From: Clare Dales
Sent: 21 March 2018 13:50
To: Anita Gardner
Subject: RE: Planning Consultation on: LY/4/18/L

Listed Building Consent for Alterations, Extension or Demolition of a Listed Building
APPLICATION **LY/4/18/L**
NO:

Registered: 5th March
 2018
Site Address: Lyminster House Church Lane Lyminster BN17 7QJ
Grid Reference: 502473 104803

Description of Works: Listed building consent for the replacement of wooden driveway gates.

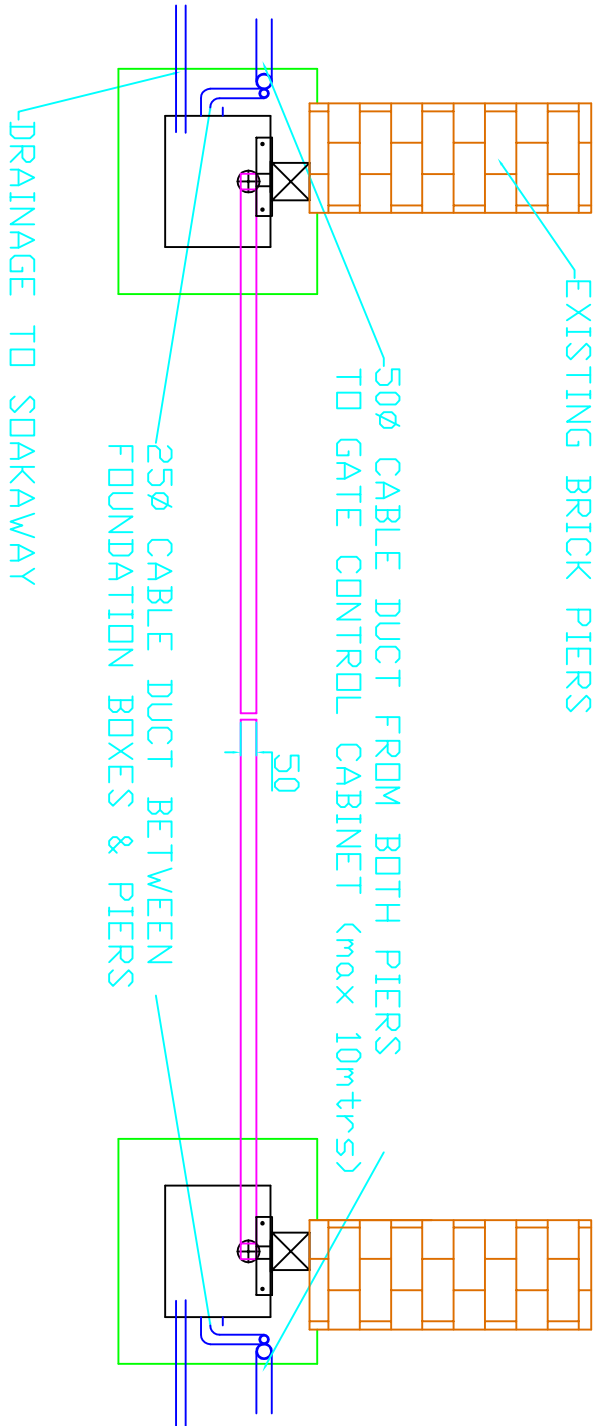
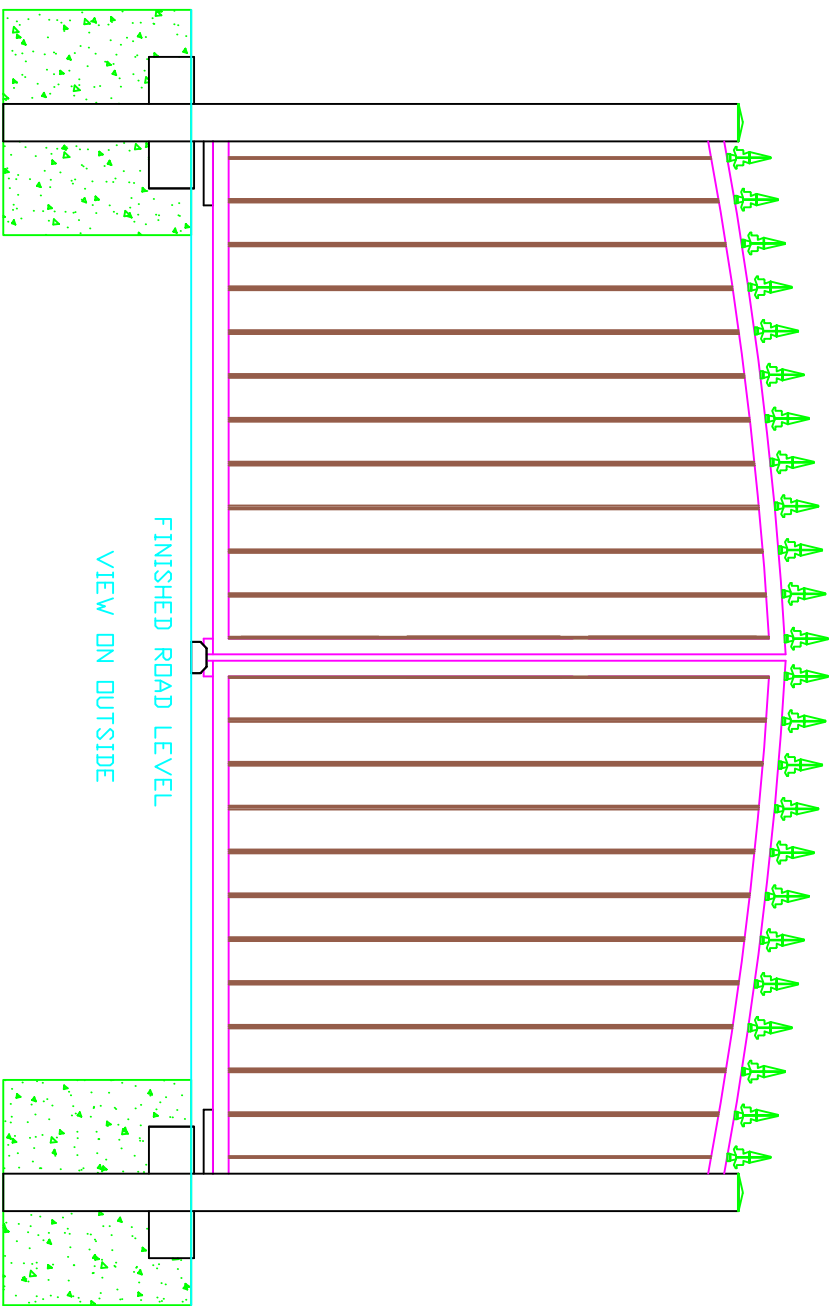
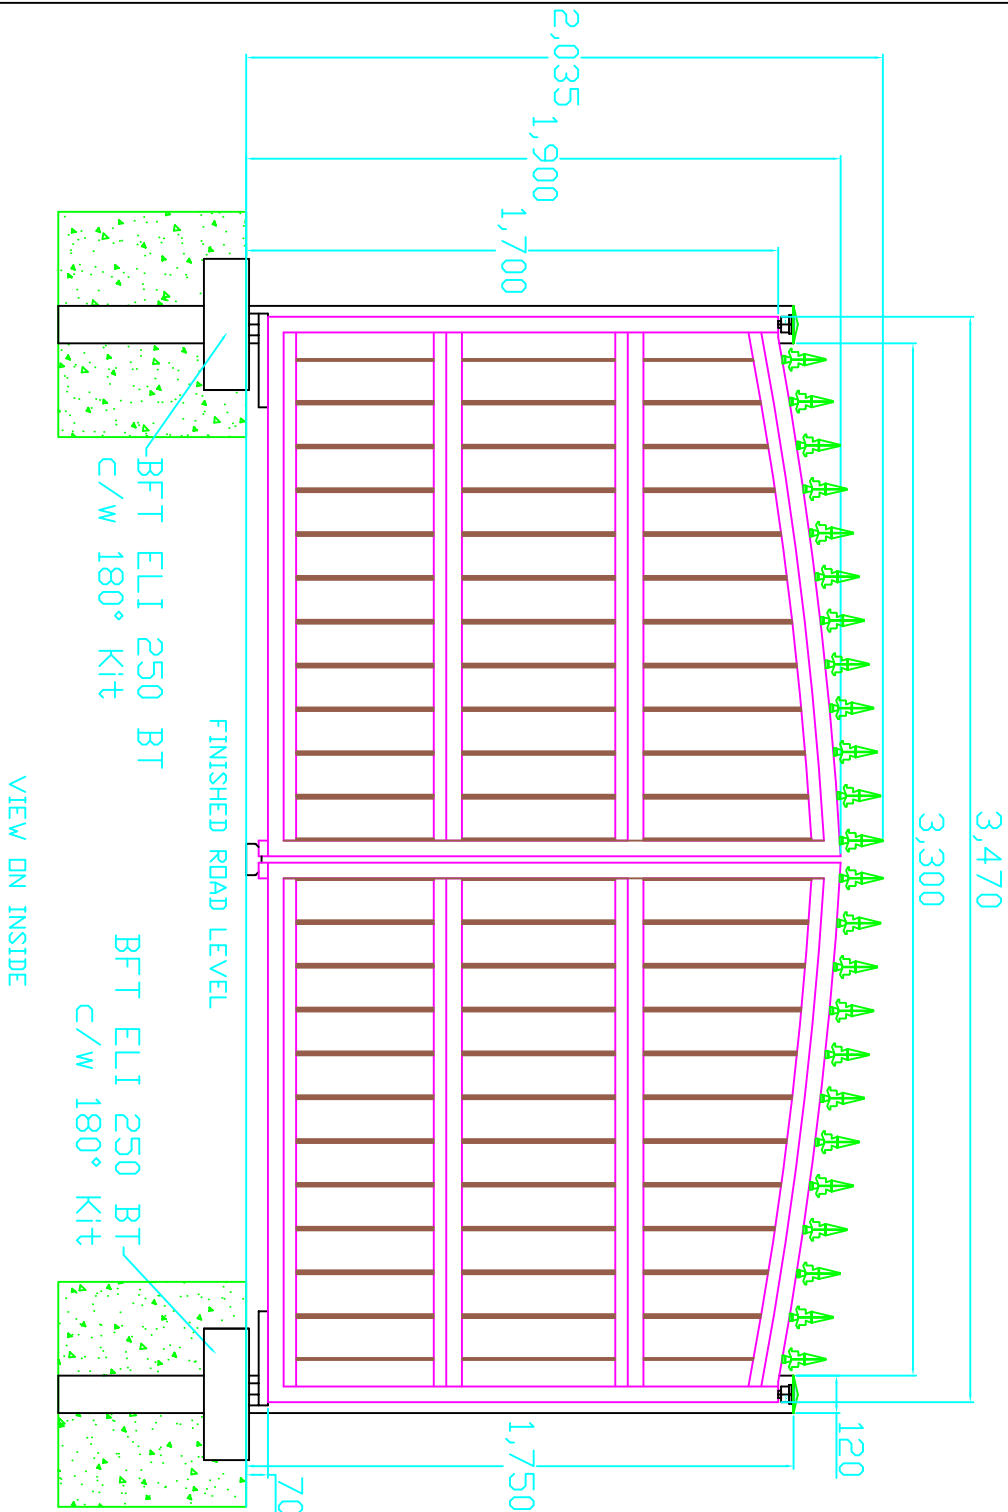
While there is no objection in principle to the replacement of the gates, including an automation system, it is recommended that the profile of the replacement gate be either: horizontal to top edge, giving a more traditional profile OR downsweeping OR be metal gates. There is a concern that the new steel posts to support the proposed gates would be visually intrusive, and it is preferable that these be set to brick piers (concealing electrical works/mechanisms etc). Other than this, a manual gate could be fitted.

I trust the above is of assistance, and I would currently recommend the proposed gates be refused.
